From: [Debbie Bogart](#)
To: [Jeremiah Cromie](#)
Subject: VA 23 00003 Zoning Variance Application
Date: Thursday, May 11, 2023 4:49:41 PM

The following comments are being submitted regarding VA 23 00003 Zoning Variance Application
Landowner Sparks Park LLC C/O Lisa Weis
Agent AJ Sandhu
Tax Parcel number: 778834

PRELIMINARY SITE PLAN
 MOUNTVIEW GROUP LLC TRAVEL CENTER
 WEST SPARKS ROAD
 EASTON, WASHINGTON

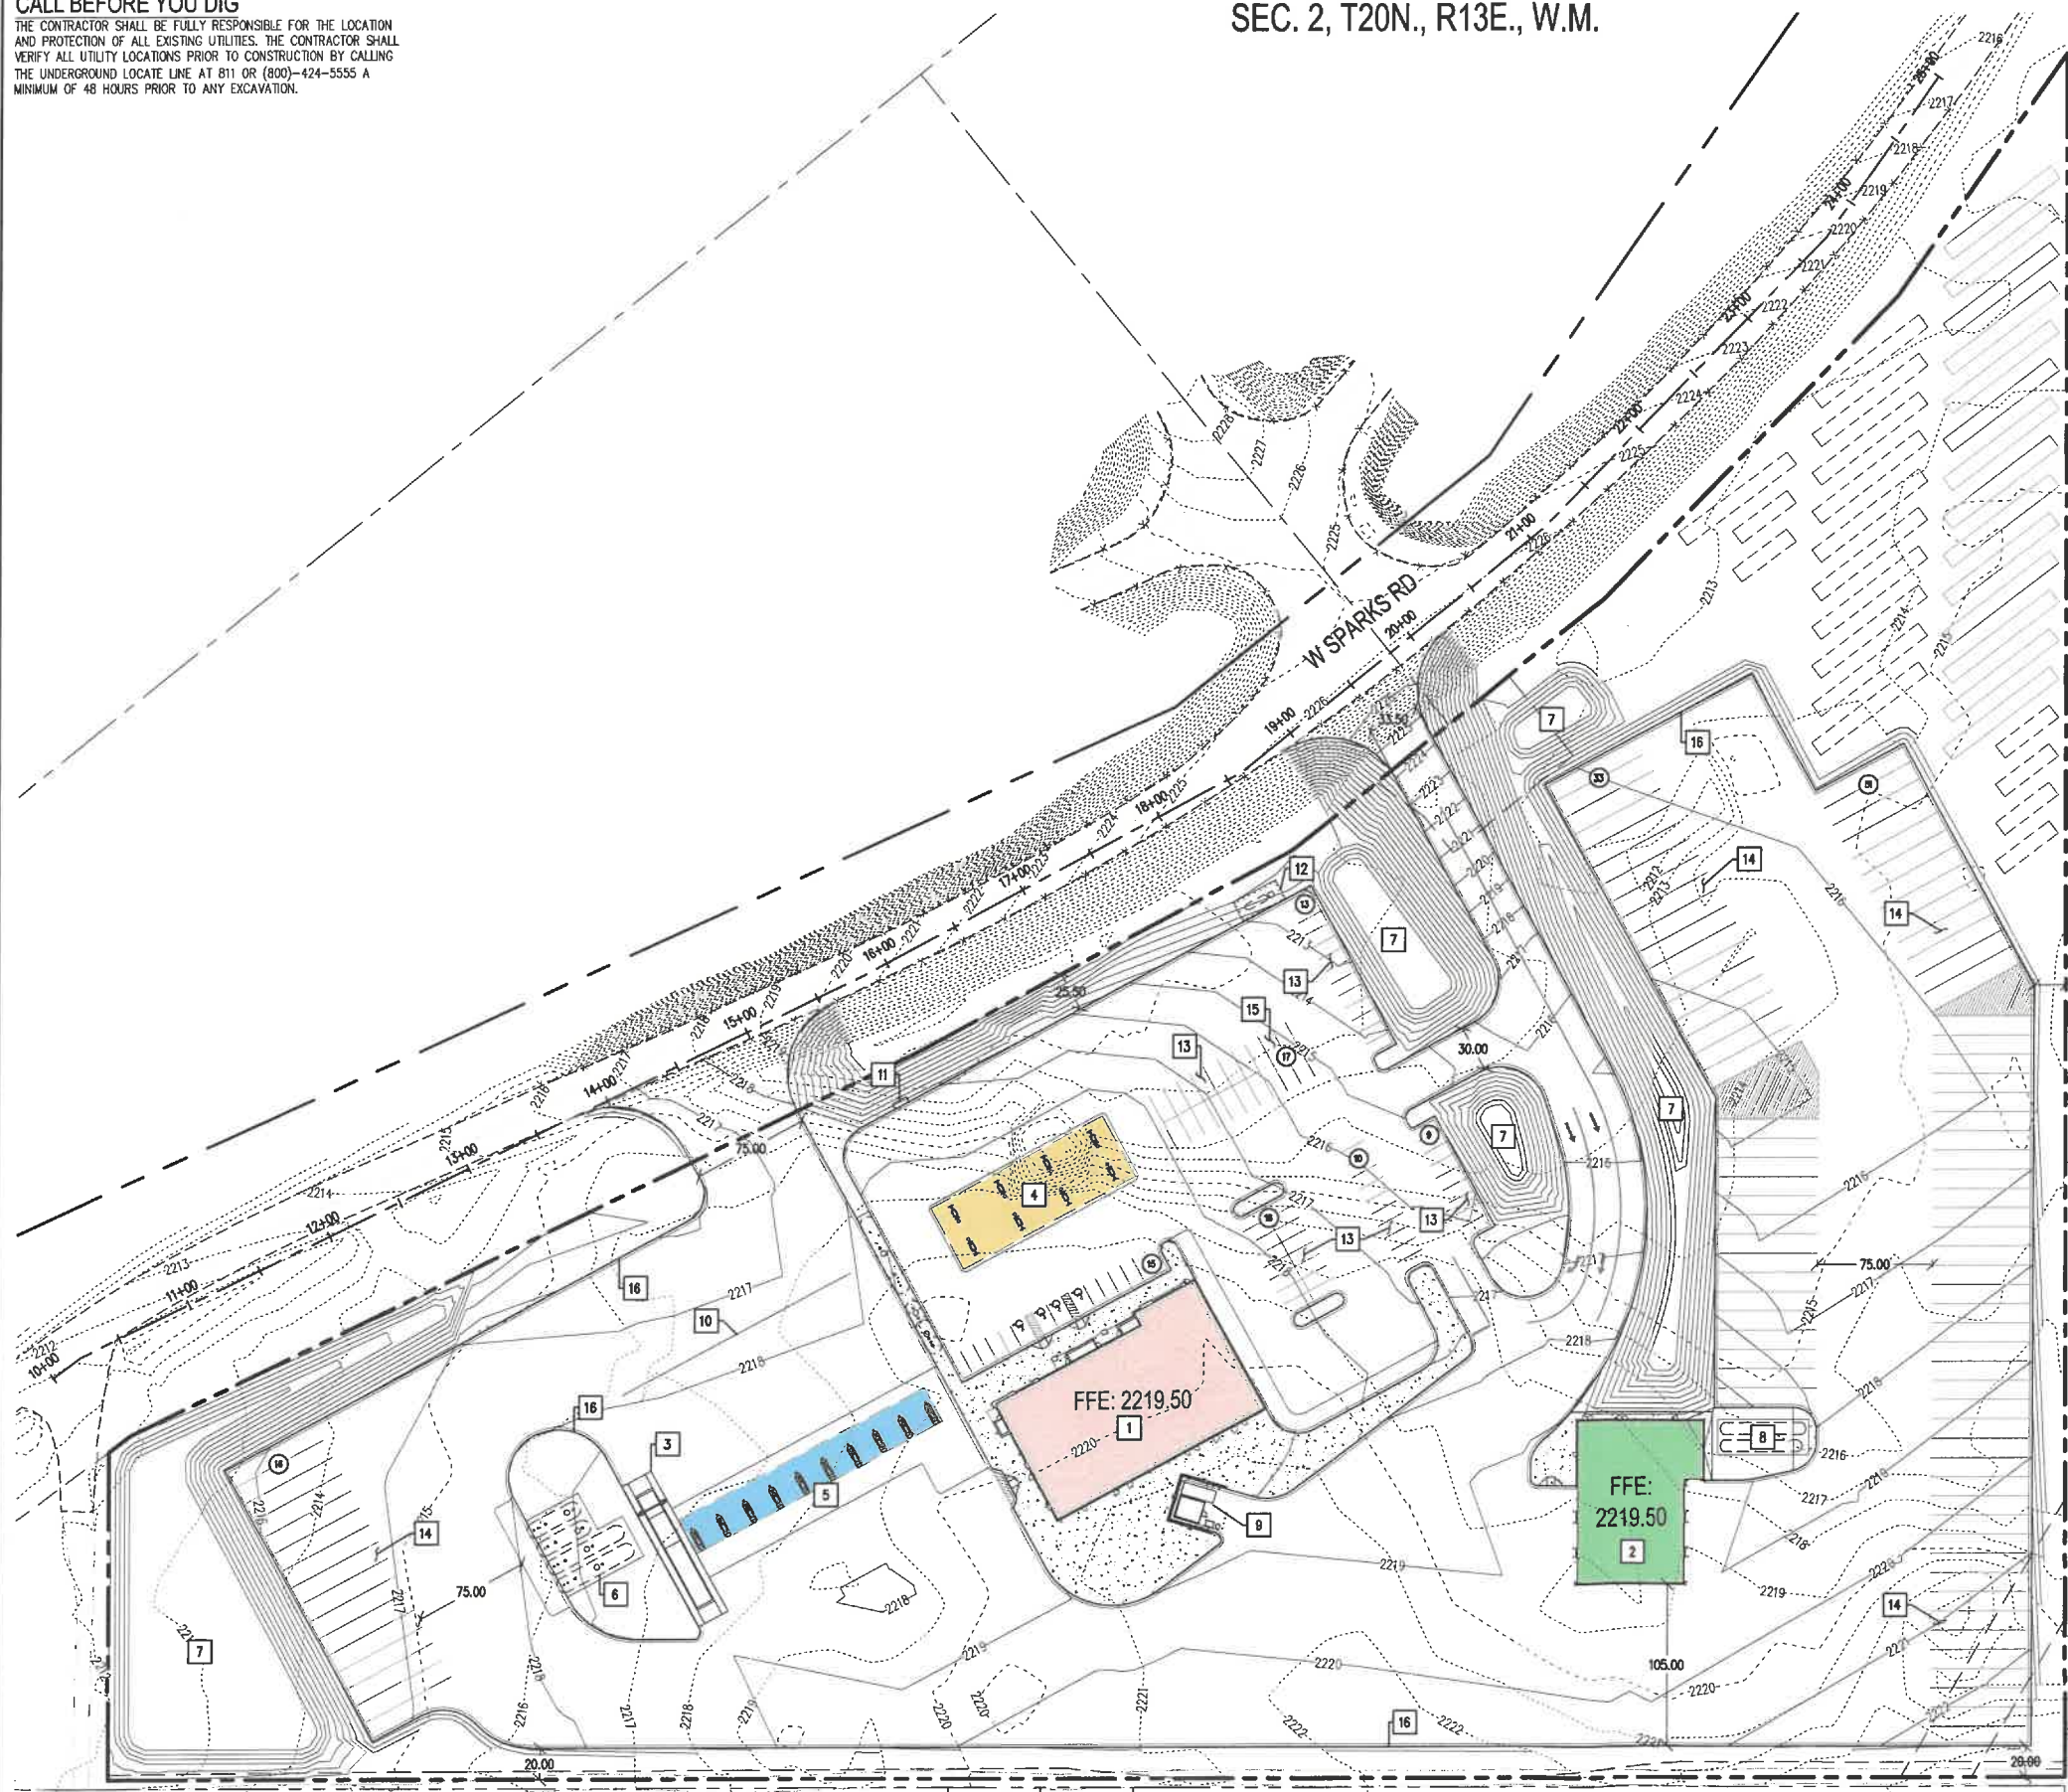
- The level of impervious surface that the applicant states, which at the level of 74% ,does not reflect the goals stated within the Type 3 LAMRID that this area has been zoned for.

- Water runoff, specifically management of storm water has not been thoroughly identified. There is no method of collection, including management of large amounts of snow that will need to accumulate and then add to the level of runoff that will add additional impact to the area being developed and to the surrounding lands.
